City of Ryde Submission

IVANHOE ESTATE REDEVELOPMENT - STAGE 2

SSD-15822622

Submission Date: 12 November 2021

Figure 3 - Loading dock

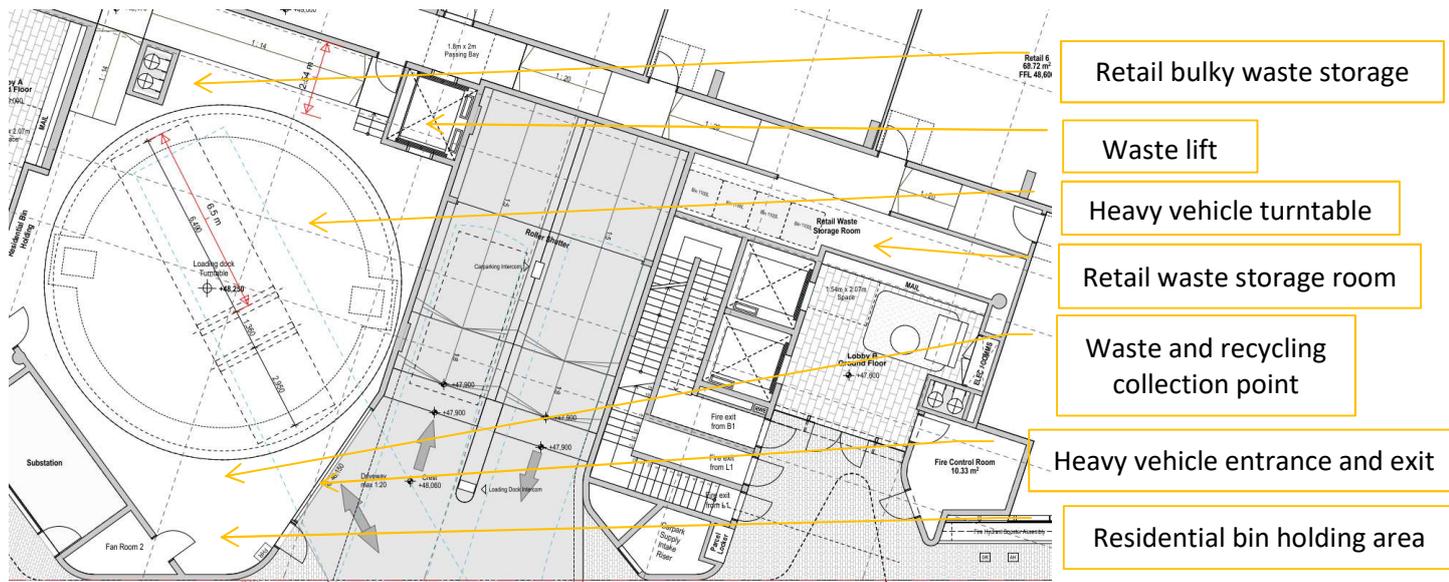
- i. Building C3 comprises 168 residential dwellings and seven (7) retail tenancies over 17 storeys. Access is proposed via Neighbourhood St Road 3 to a ground floor loading dock. The waste truck will utilise a turntable which accommodates a 12.5m HRV. The same driveway is used for residential vehicular access. There are concerns surrounding the visibility of cars coming up the ramp exiting the driveway while the waste truck departs from the loading dock area. This needs to be reviewed from a safety and WHS perspective.

- iii. The residential bin holding area at the rear of the Loading Dock Turntable is not large enough to house the above 19 bins – The loading dock area needs to be amended and the plans are to show the above bin configuration to ensure that they can be stored without impeding on the turntable area.

Figure 2 – Social waste storage areas on Basement 1

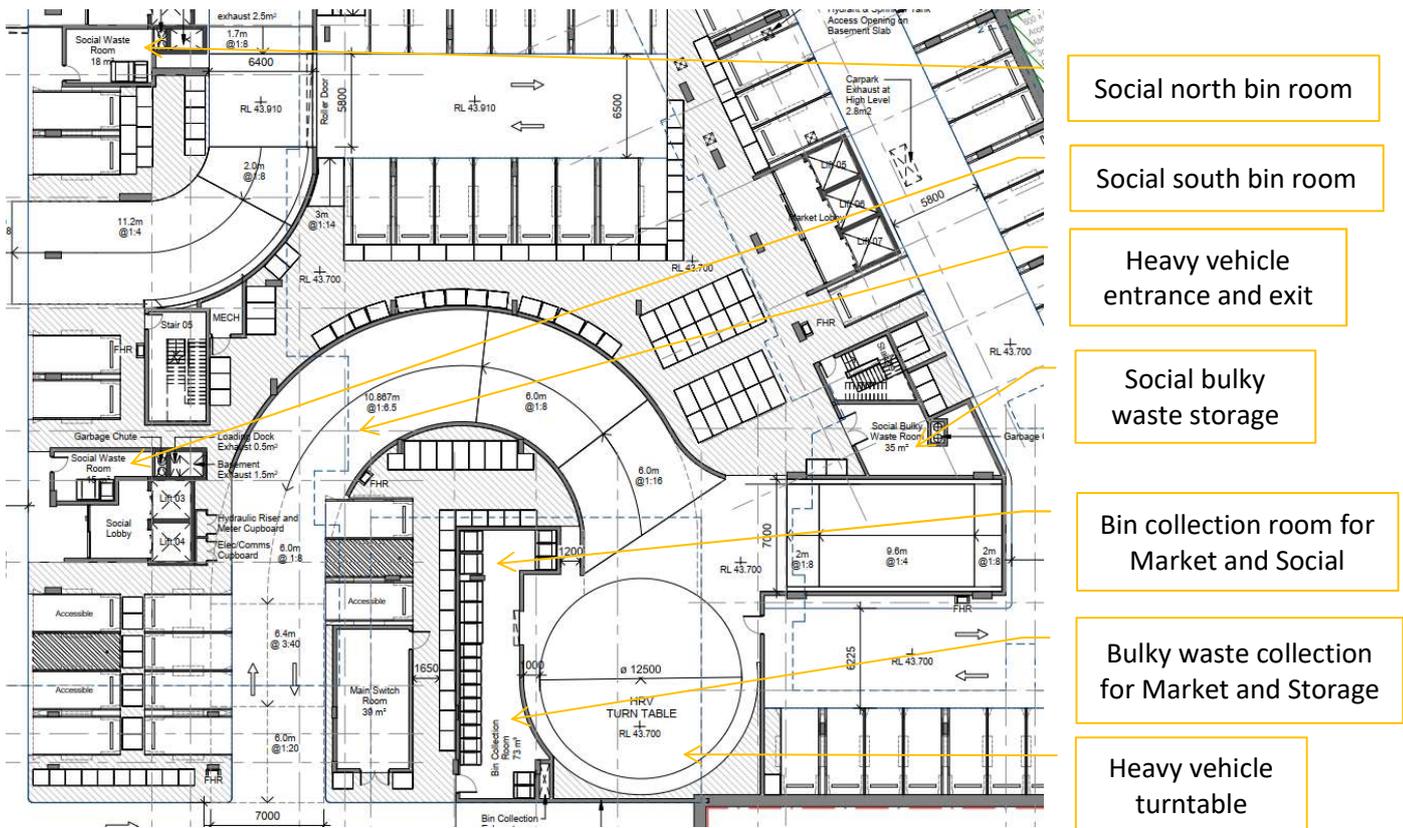
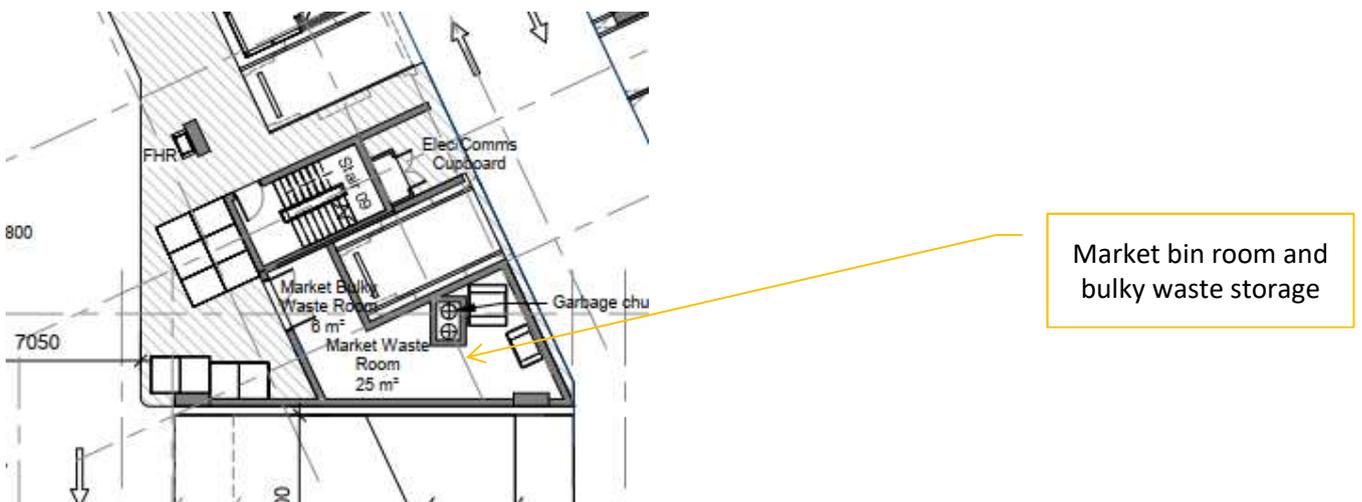
- iv. There are dual chutes (one for waste and one for recycling) located on each floor of both Building A & B. The chute rooms on Basement 1 shows that waste will be compacted. Council does not allow for compactors due to breakage of the bins. The plans need to show that the above bin configuration can fit into the chute rooms.

- v. The Bulky Waste Room is included as part of Building B waste store room. The bulky waste room needs to be a separate room so that access to the bins is not blocked and residents do not access the chute room. Plans need to be amended to provide a separate bulky waste storage room. It is suggested that the Bulky Waste Room is located on the ground floor adjacent to the loading dock to provide a more efficient service. Safe access for residents is to be considered when relocating the bulky waste storage room. This will be more efficient for the building manager in not being required to move the cleanup items from the Basement to Ground Floor.

- ii. The access driveway is very tight in the horseshoe and should be revised to ensure that the waste truck can manoeuvre without issues.
- iii. The Waste Management Plan prepared by SLR Consulting shows that there will be only a total of 8 x 1100L waste bins and 17 x 660L recycle bins for the 488 units. This equates to 44L per unit which is not adequate. The bin configuration should be:
